DECISION DELEGATED TO HEAD OF PLANNING

Application No: H07-0907-21 **Applicant:** Mr K Mitchell
Proposal: Details of foul & surface water disposal (Condition 3 of H07-0411-21)
Location: Plot 1 South Of Highstock Lane Gedney Hill
Terminal Date: 12th November 2021

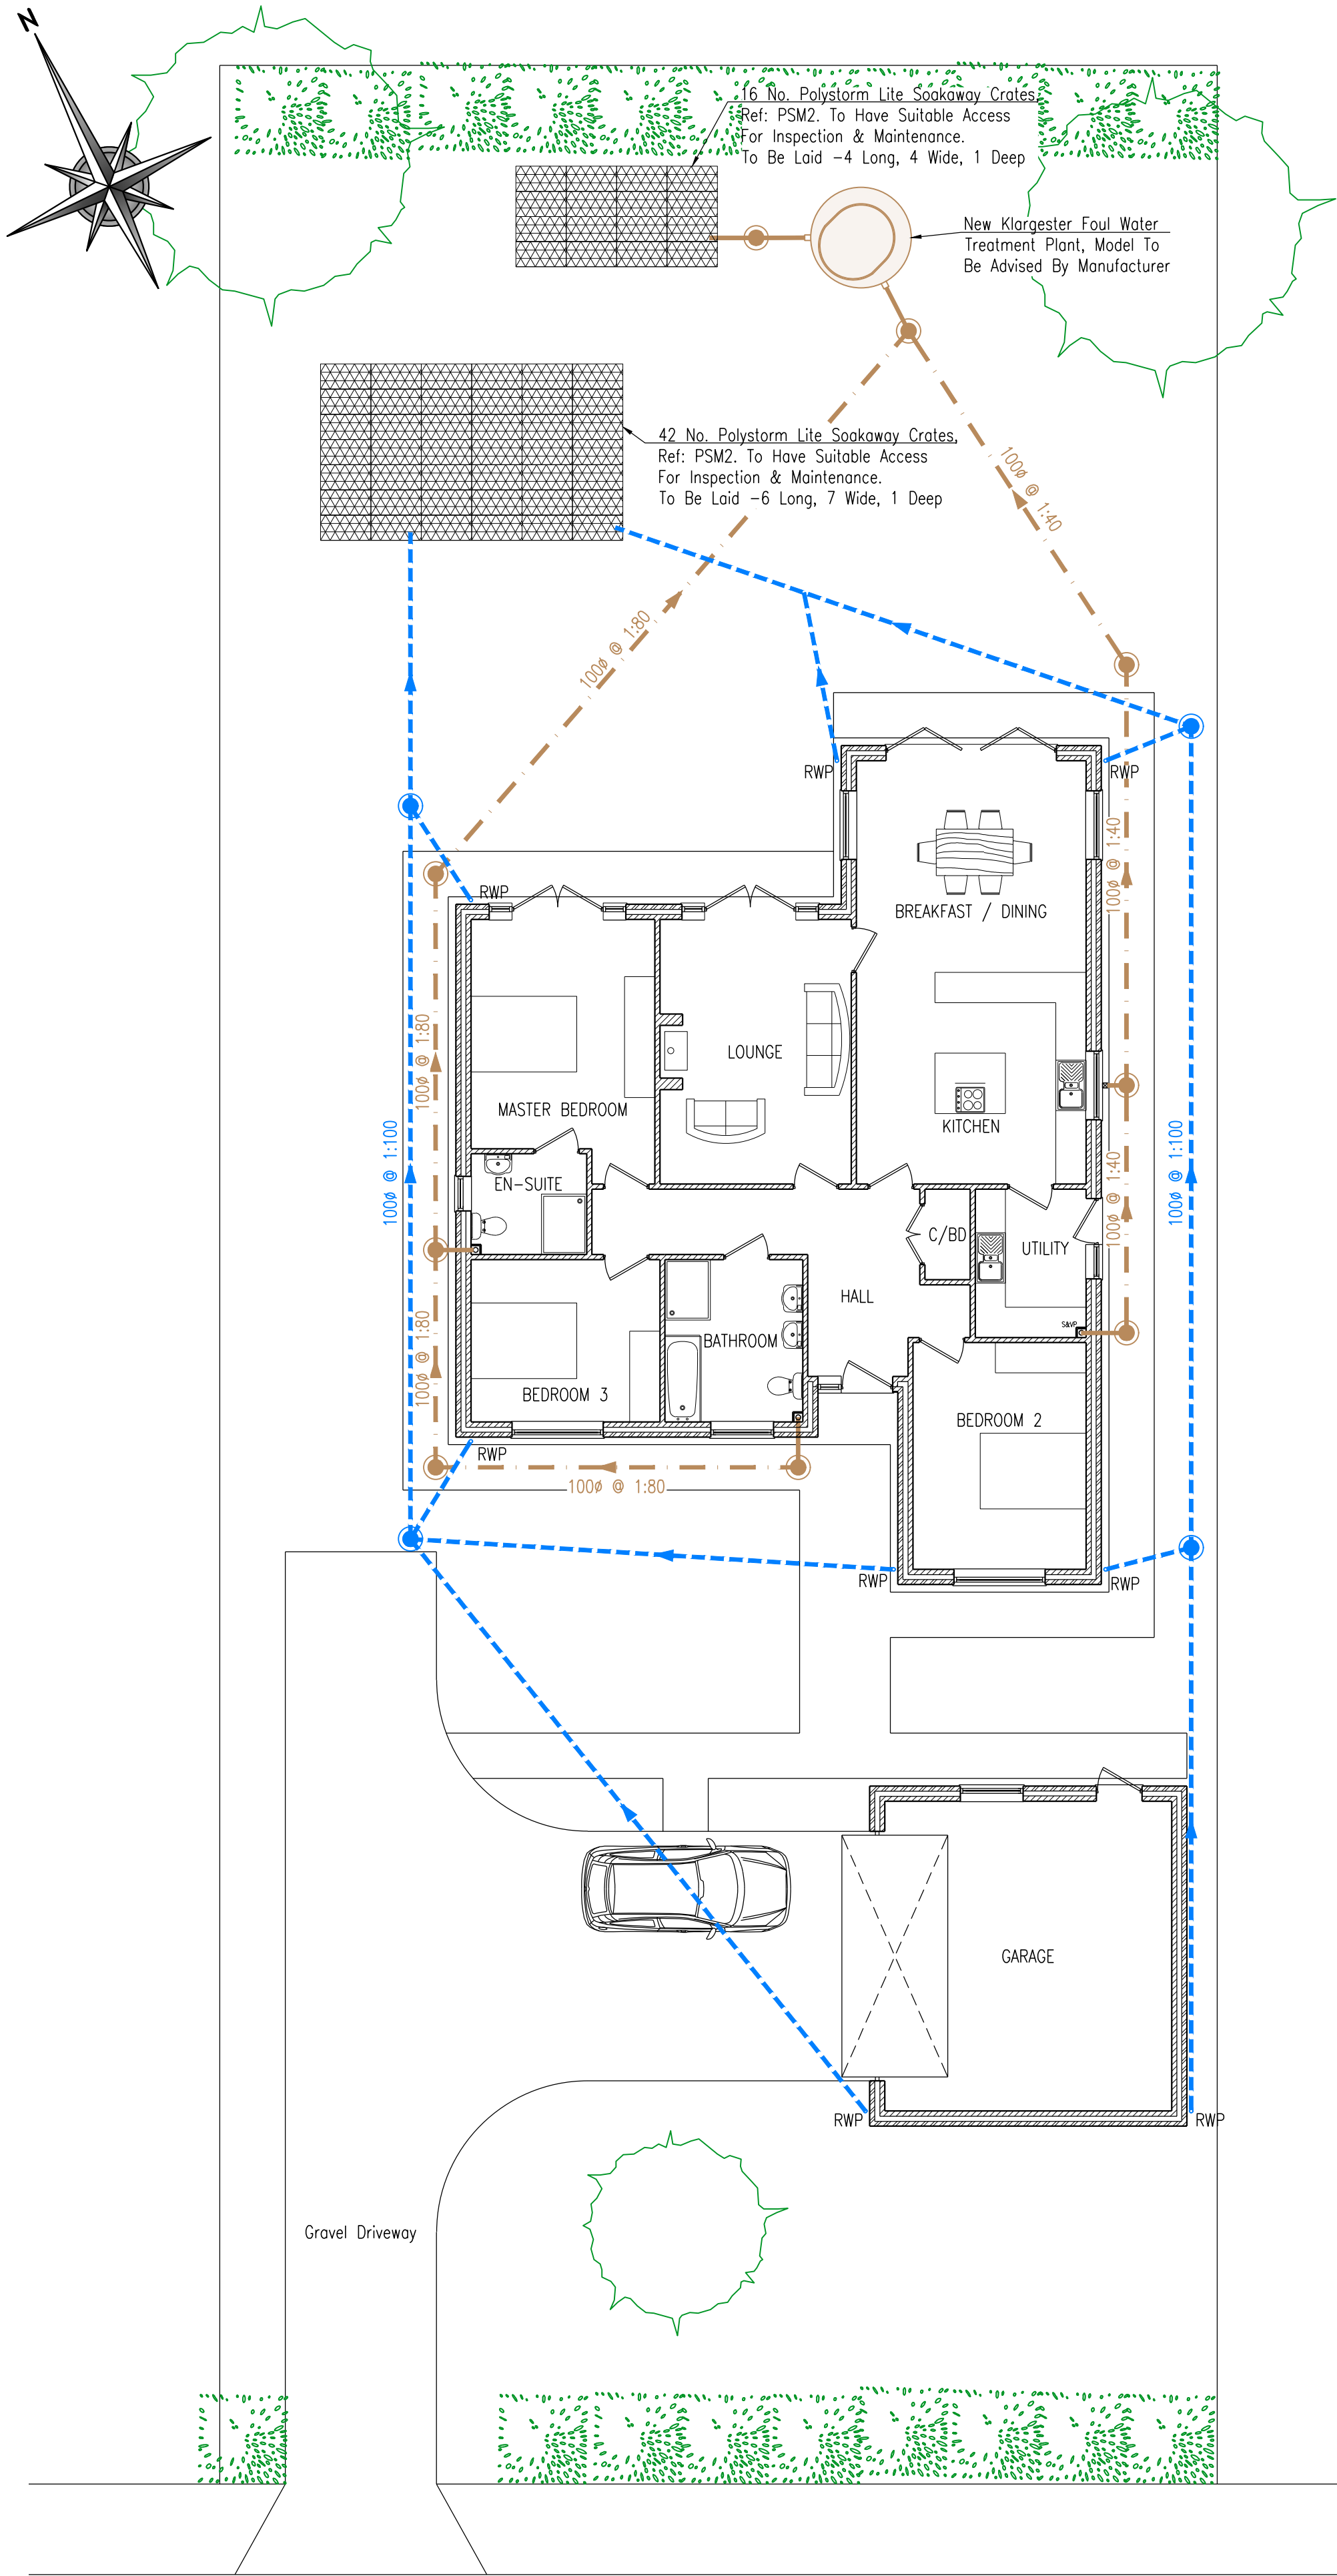
We accept that the soakaways for surface and foul water are to be located to the rear (north) of the property. We understand that the soakaway calculations (lodged 25-08-21) align with Building Regulations requirements and the proposed soakaway crate volumes are acceptable for this development.

The South Holland Internal Drainage Board has advised that the soakaways for surface and foul water proposed to be to the rear (north) of the property in accordance with drawing no. 16721/01 (Proposed Drainage Layout) are considered acceptable. In addition the soakaway calculations (lodged 25-08-21) align with Building Regulations requirements and the proposed soakaway crate volumes are acceptable for this development.

The proposed surface and foul water drainage scheme is considered acceptable therefore condition 3 can be discharged.
